Application No: K/2/22/HH
Site Address: 43 Golden Avenue East Preston BN16 1QX
Description of works: 2 storey front and rear extensions and alterations.

OWQC44624

Council has no objection providing the case officer is satisfied that:

Proposed Side (North) Elevation

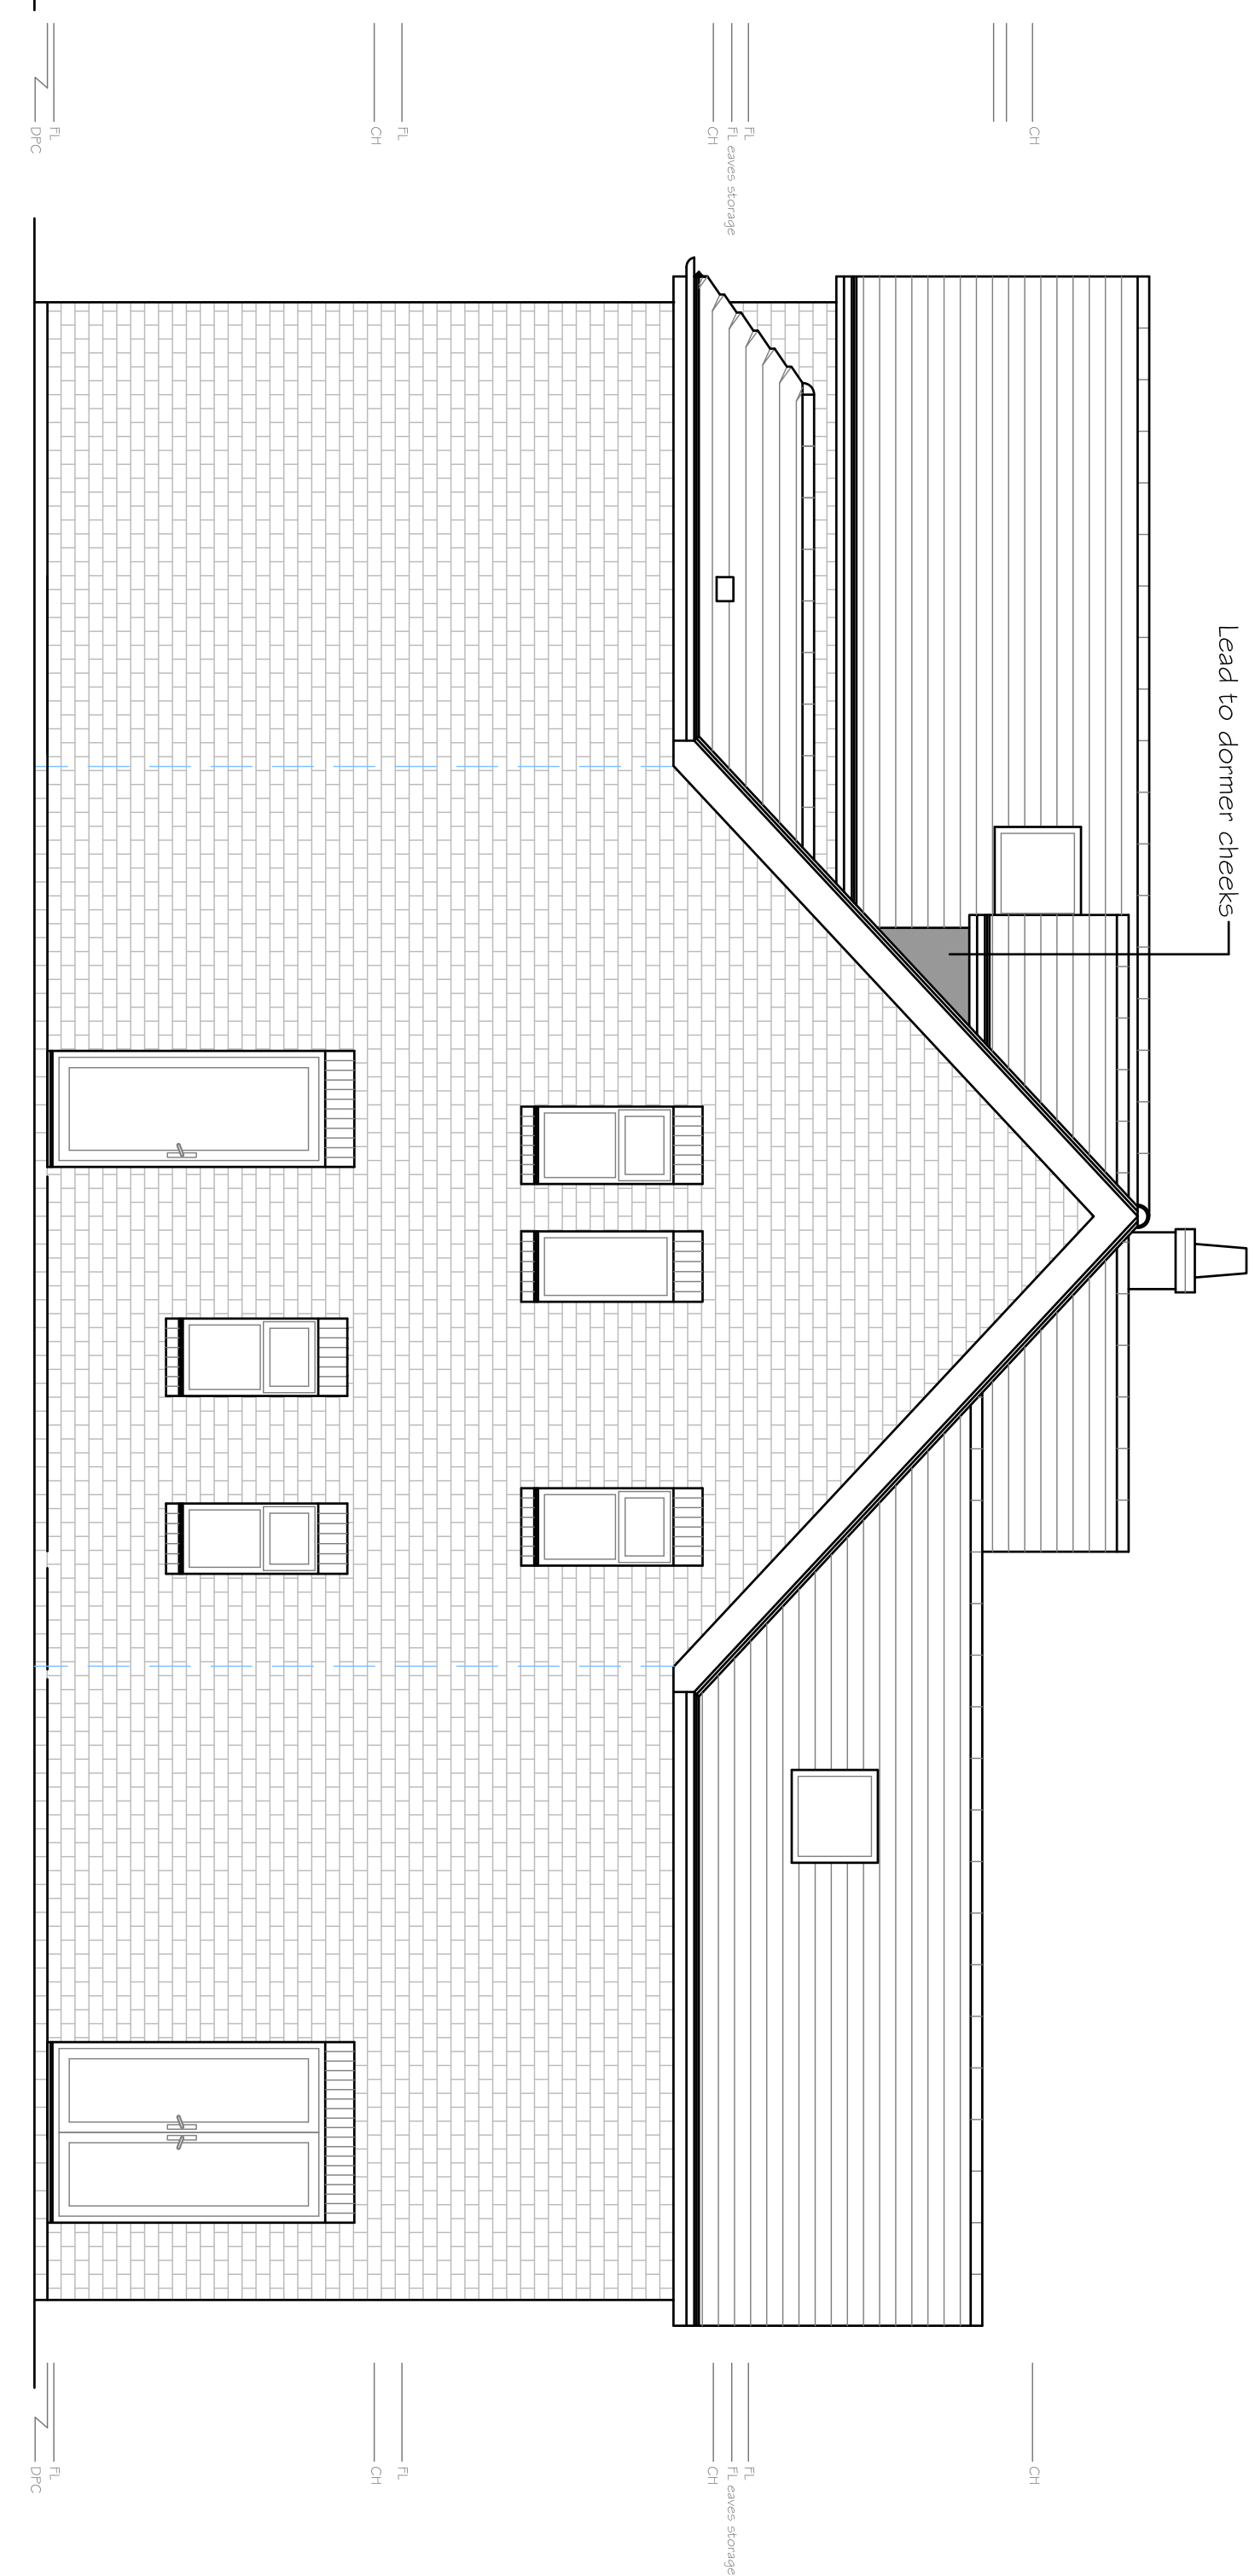
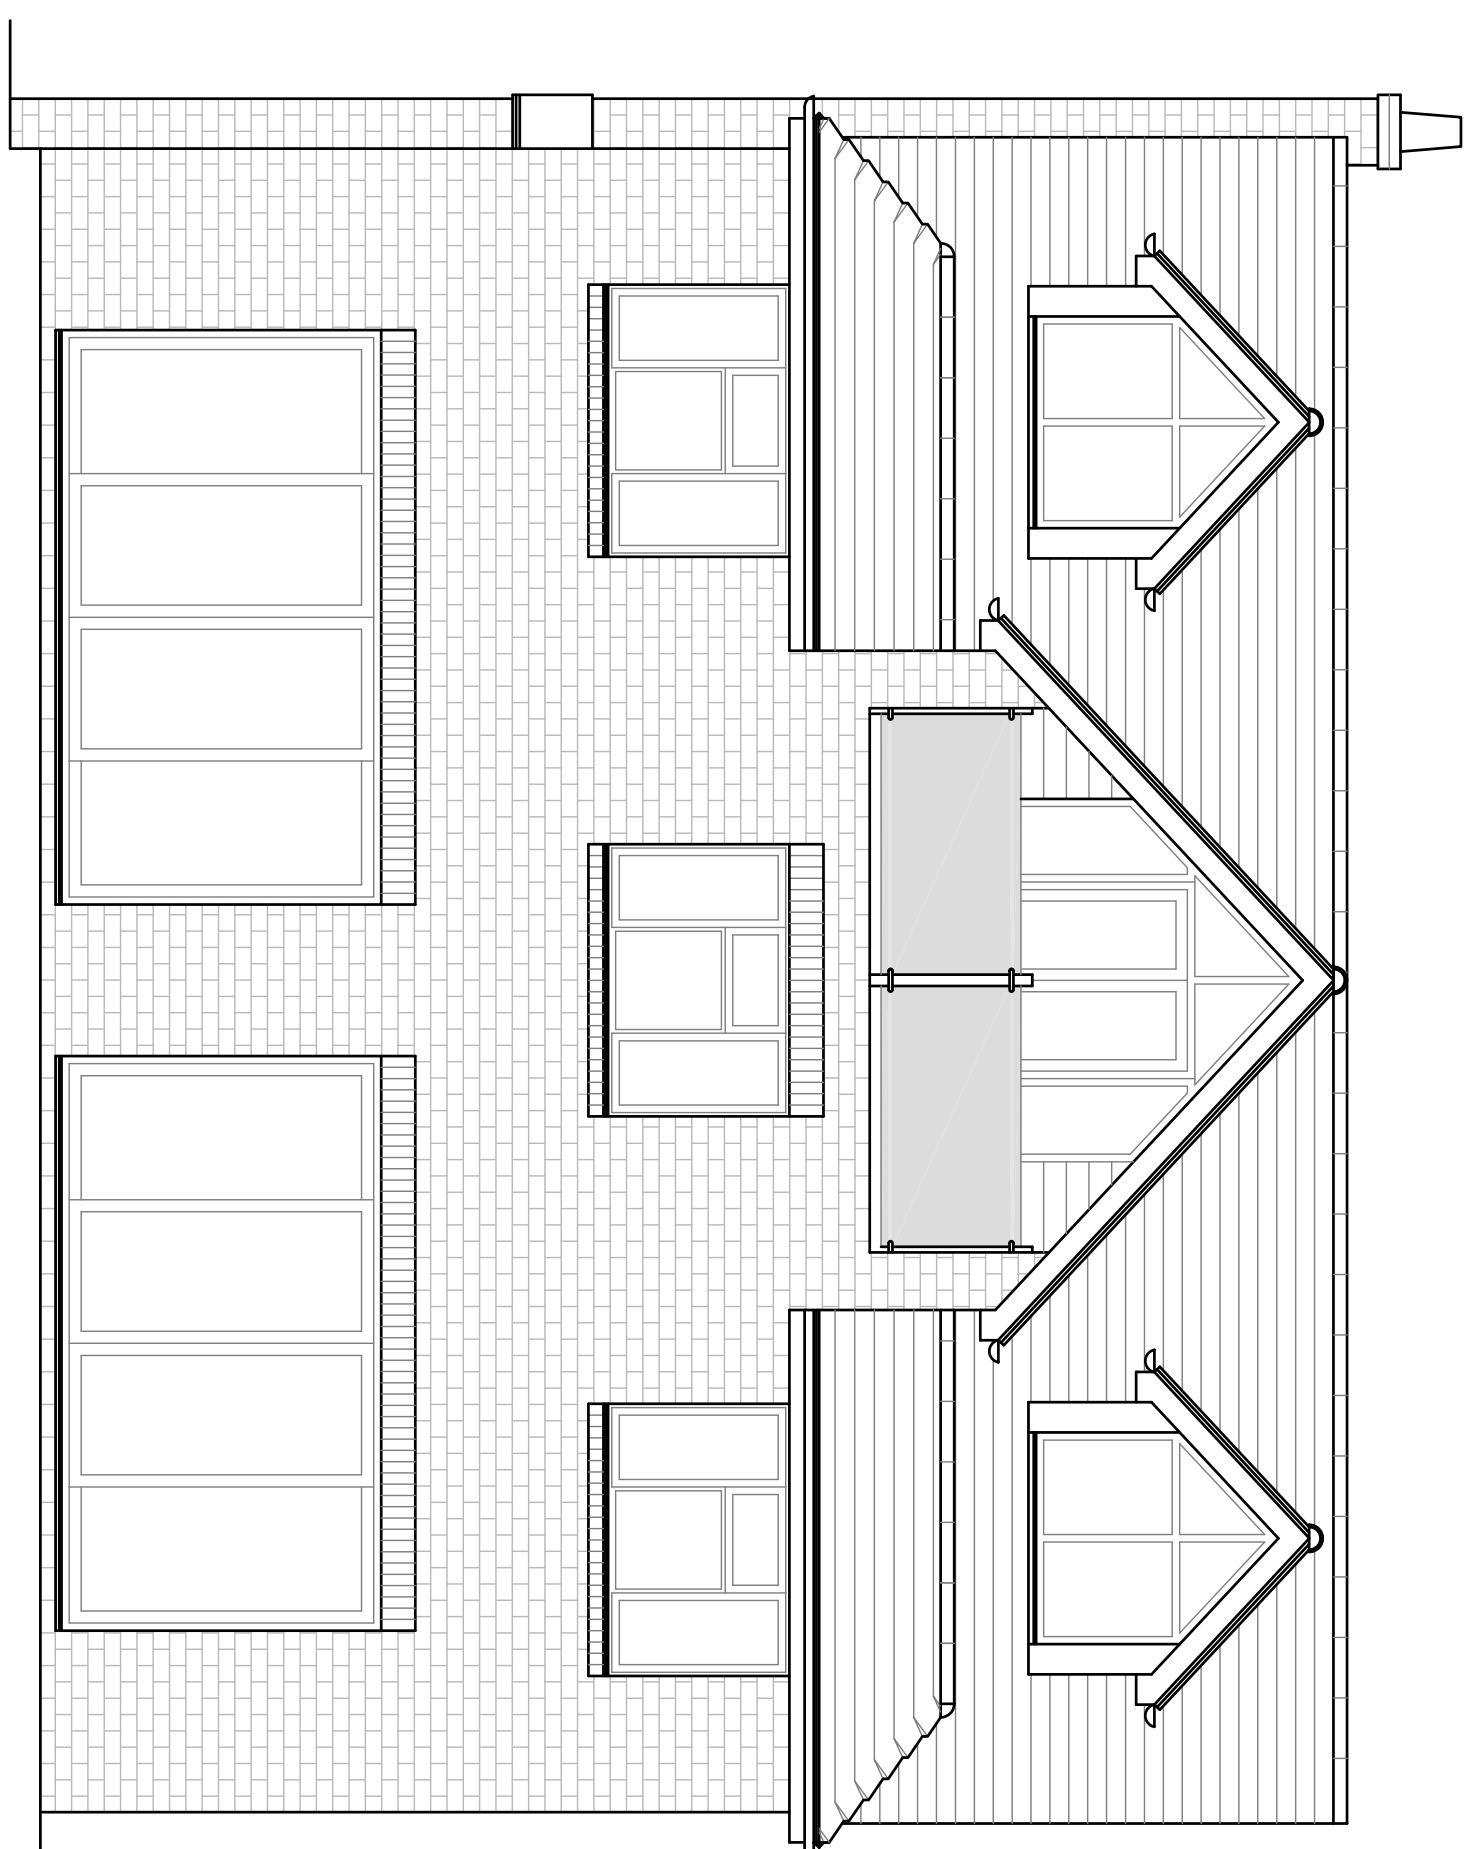
- there is appropriate on site parking for a 6 bedroom property
- windows on the side elevations have appropriate conditions as required to protect the privacy of neighbouring properties
- the new dormer windows and the new balcony at the rear on the second floor have appropriate conditions if required, to protect the privacy of neighbouring properties
